29th September 2021

RE: WEIGALL SPORTS COMPLEX, SYDNEY GRAMMAR SCHOOL (SSD-10421) - REQUEST FOR INFORMATION (IMPACT ON VIEWS/OUTLOOK)

I have been engaged by Sydney Grammar School to provide further advice in relation to the potential visual impacts on views from neighbouring dwellings located at 8 Vialoux Avenue, Paddington.

1 SECTION 01

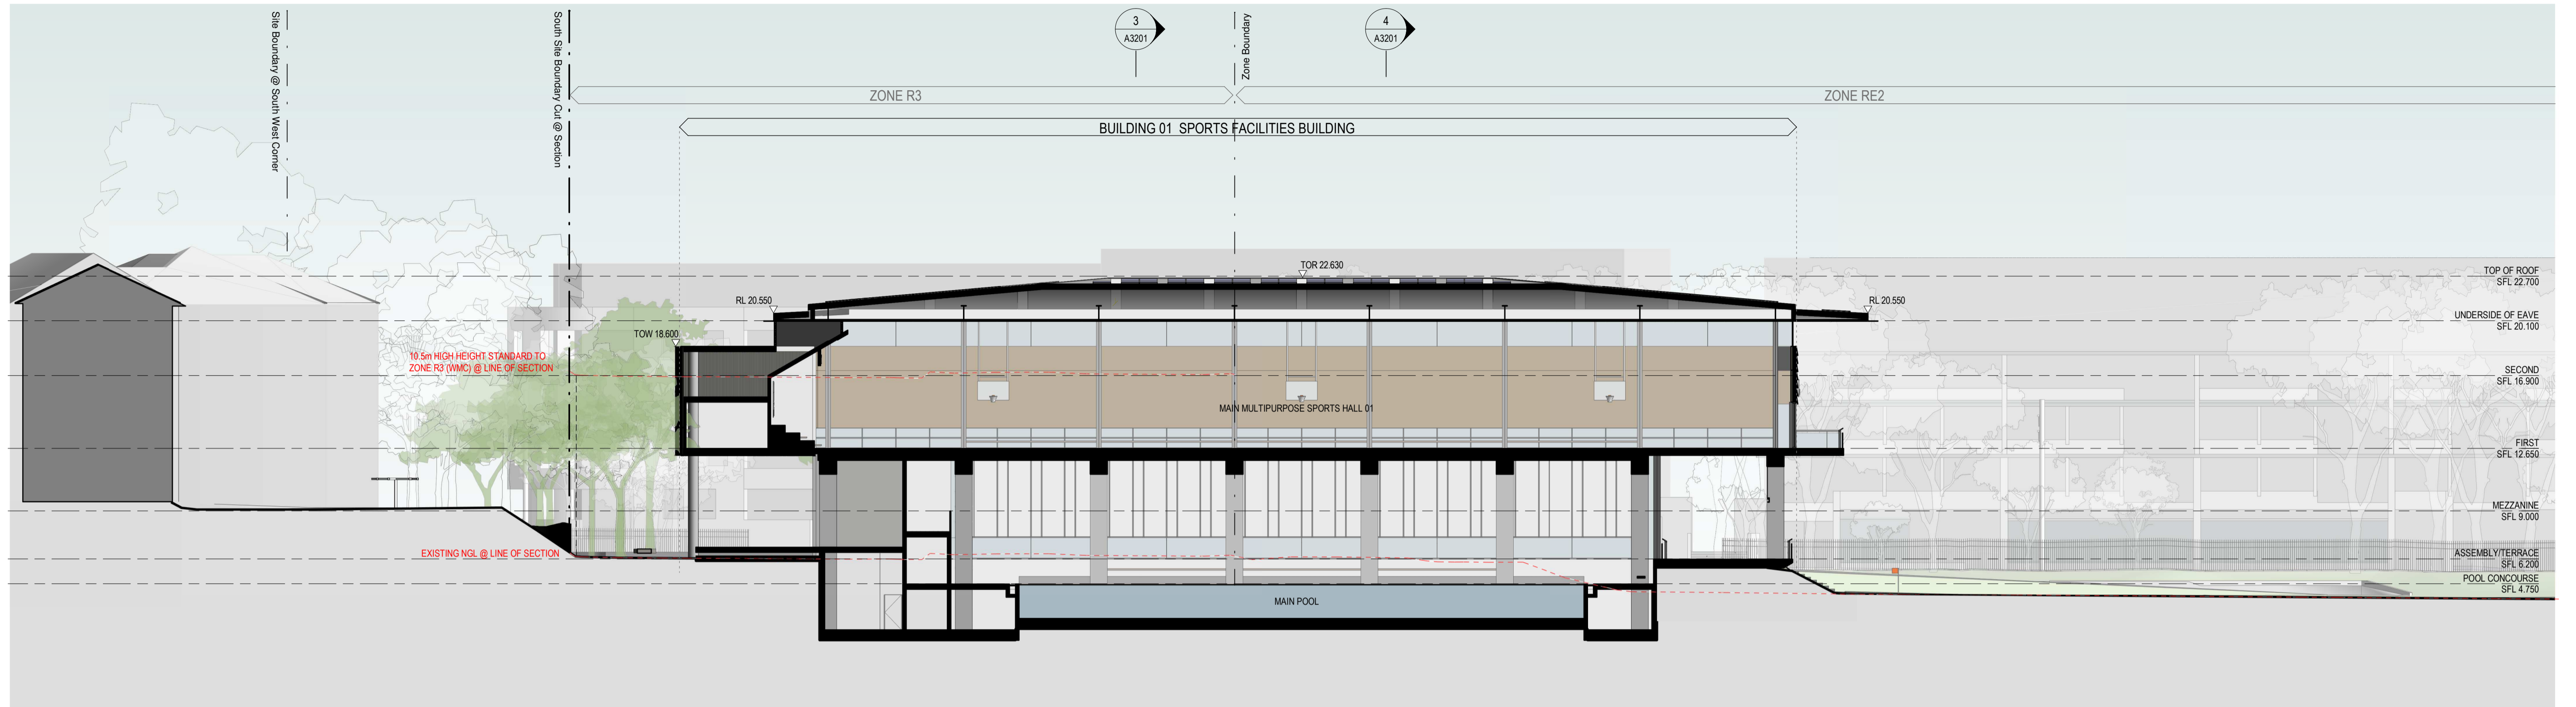
3. Level 2 Plan, Section 01 and Axonometric plans show that setbacks from the southern site boundary to the built form proposed, have been significantly increased by 4.0m to MPSH2 and 3.0m to MPSH3.

4. In fact Section 01 shows the 'worst case scenario', being the closest part (south-east corner) of the Aquatic Hall where, north of this corner, built form angles northwards so that the northern units for example units 8 and 12/8 Vialoux Avenue are between 18.0m and 22.5m away from the MPSH 2 and 3 respectively.
